Application number: 22/03063/F

Location: Land East Of Larsen Road Heyford Park

Proposal: Erection of 126 dwellings with access from Camp Road, provision of public open space and associated infrastructure.

Objection:

TITLE: Arboricultural Impact Plan	
LAYOUT: Site Overview	
PROJECT/SITE: Land off Camp Road, Upper Heyford	
CLIENT: David Wilson Homes	
MAP REF: 22-0728	
REVISION: v4	
DATE: 15/09/2023	SCALE: 1:1000@A3
APPROVED BY: BJ	PRODUCED BY: SF

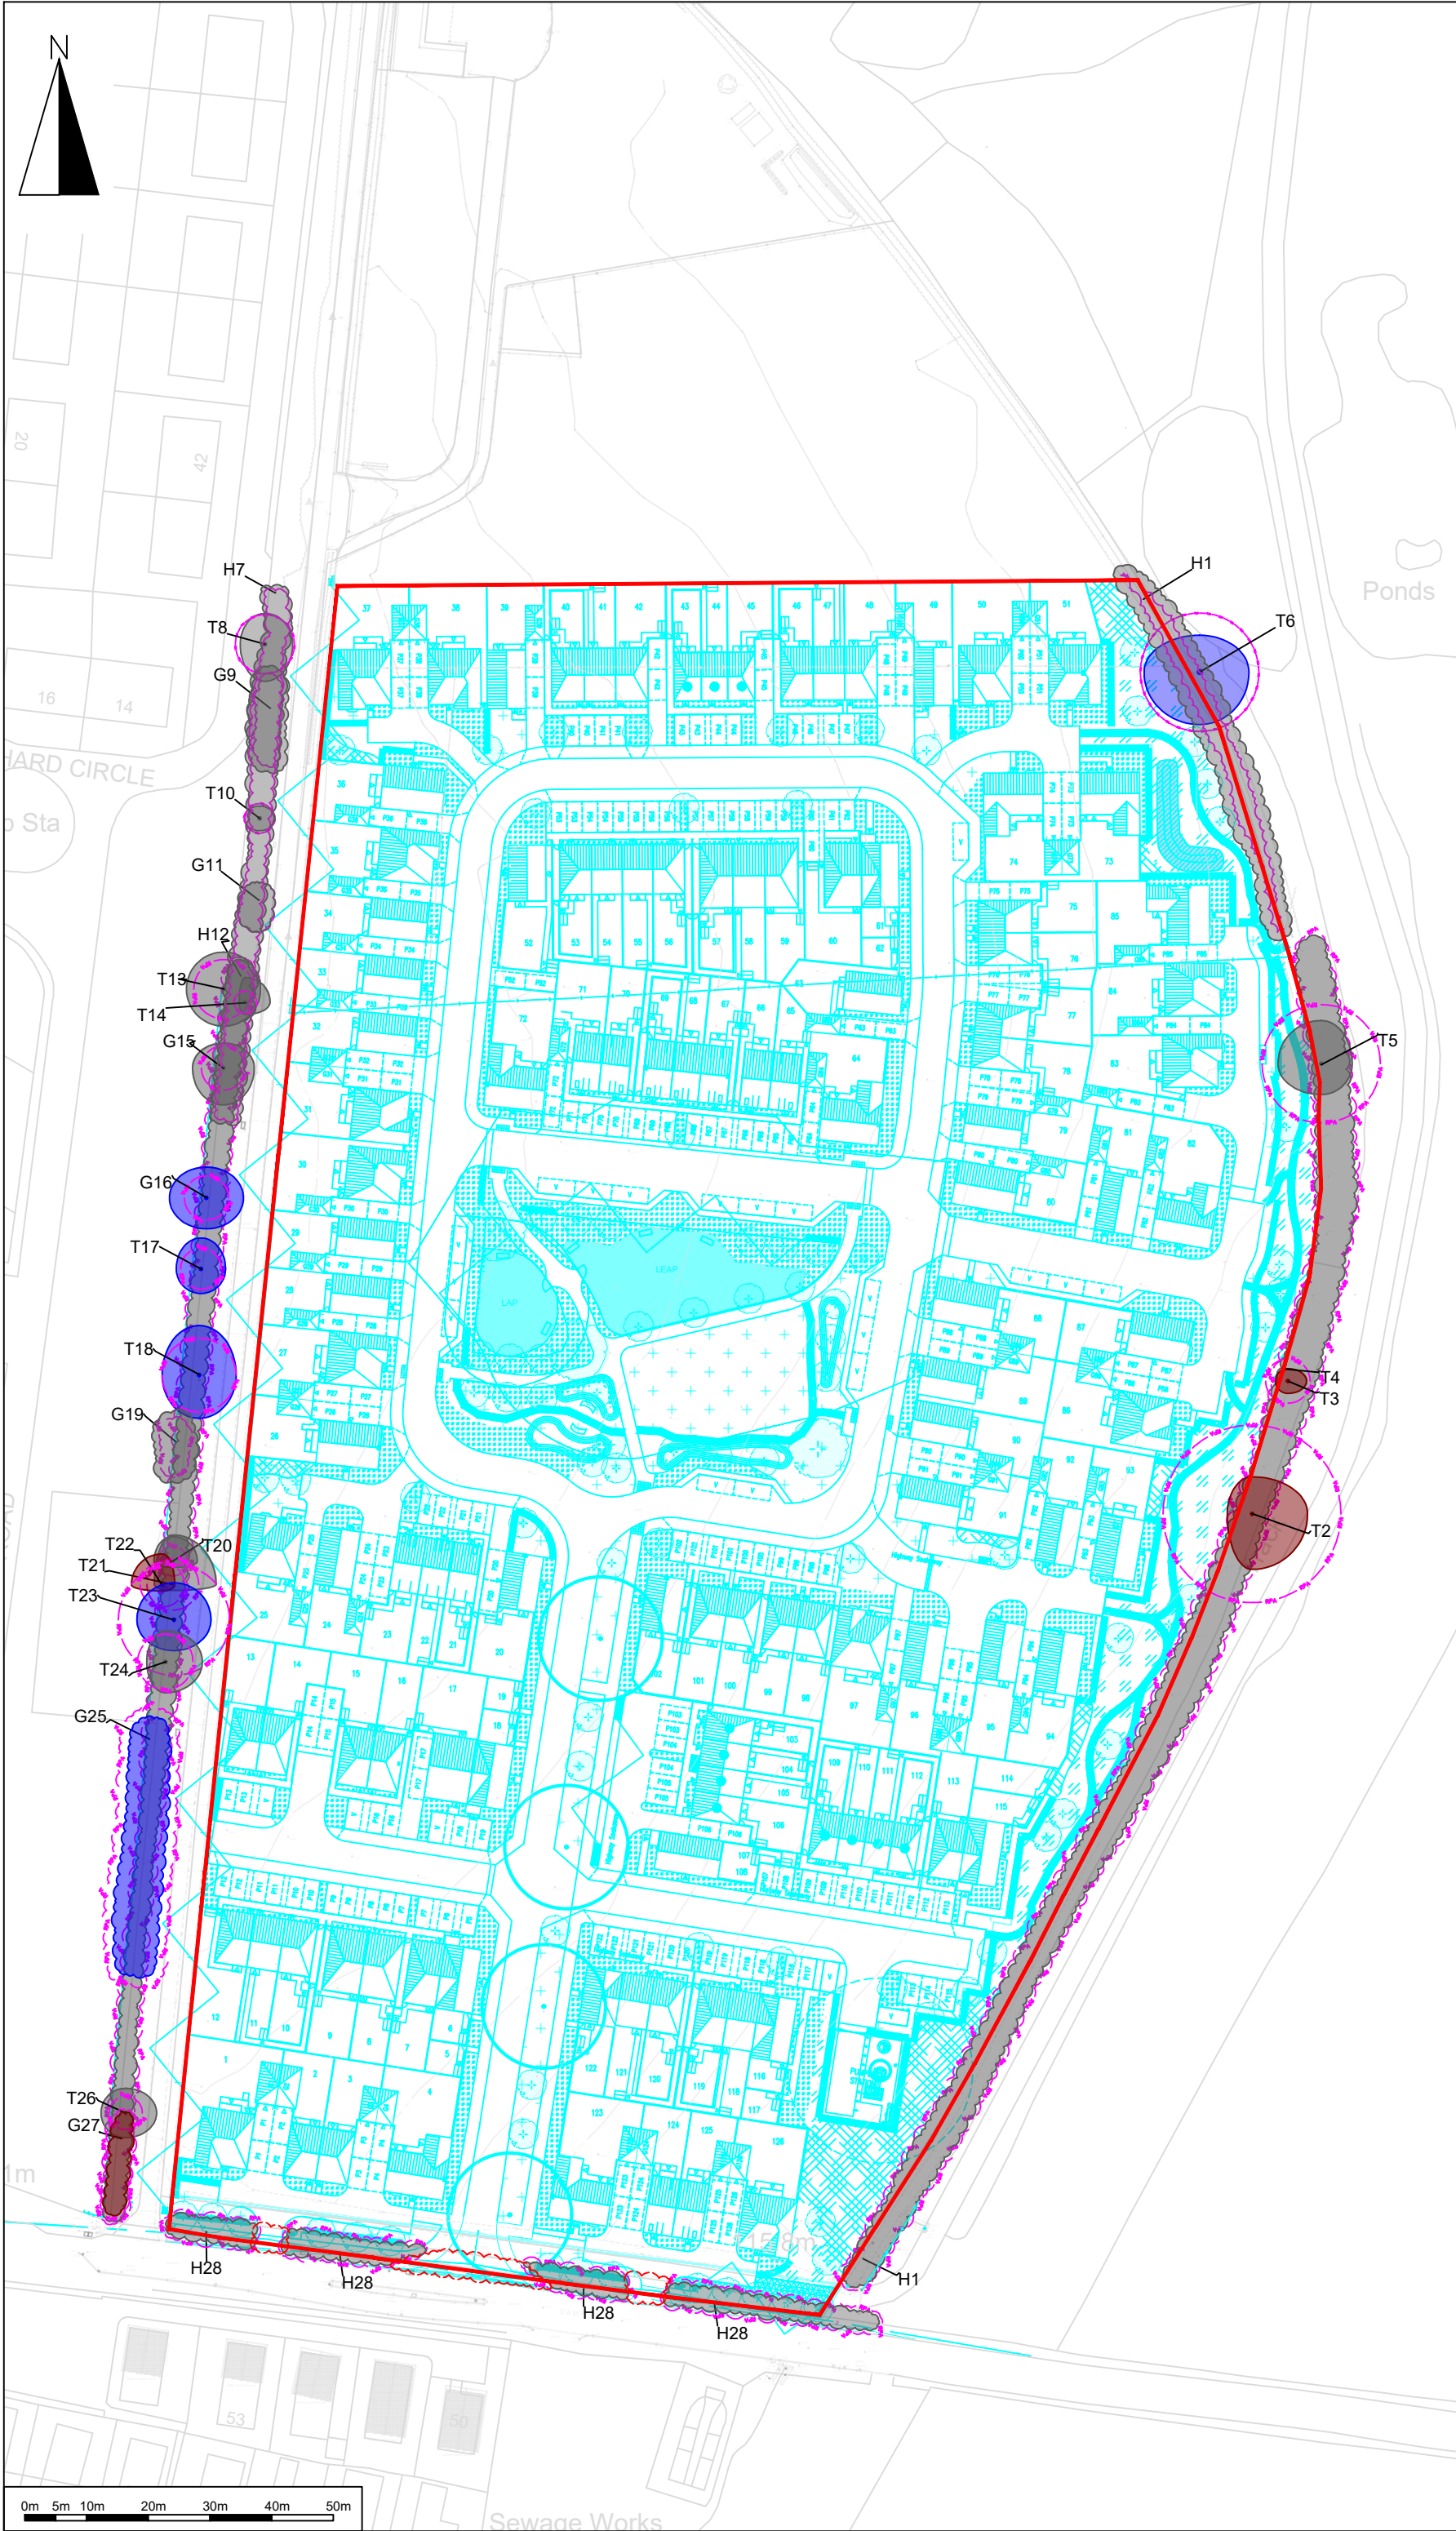
We note that the development design has considered the existing hedgerows and retains a significant proportion of them. There is also new hedgerow along the west of the site. However, we are concerned about the apparent loss of some of the hedgerow (particularly along the southern edge of the site) and the impact on species dependent on the retained hedgerows.

We are concerned that newly created hedgerow will not compensate for impact on the retained hedgerow.

If the application is approved then retained hedgerows should be protected and enriched by creating buffer zones or buffers of semi natural vegetation. Buffers zones should feature:

- Minimum 10 m wide buffer zone each side of the hedgerow
- Dark corridors along the hedgerows so that both the hedgerow and the 10m buffer is protected from light

- Buffer zones should be primarily diverse grassland area alongside hedgerows so that they are suitable for invertebrates
- No built development within the buffer zone

- New planting of similar species and or translocations to create new links between hedgerows and to fill gaps in the existing hedgerows
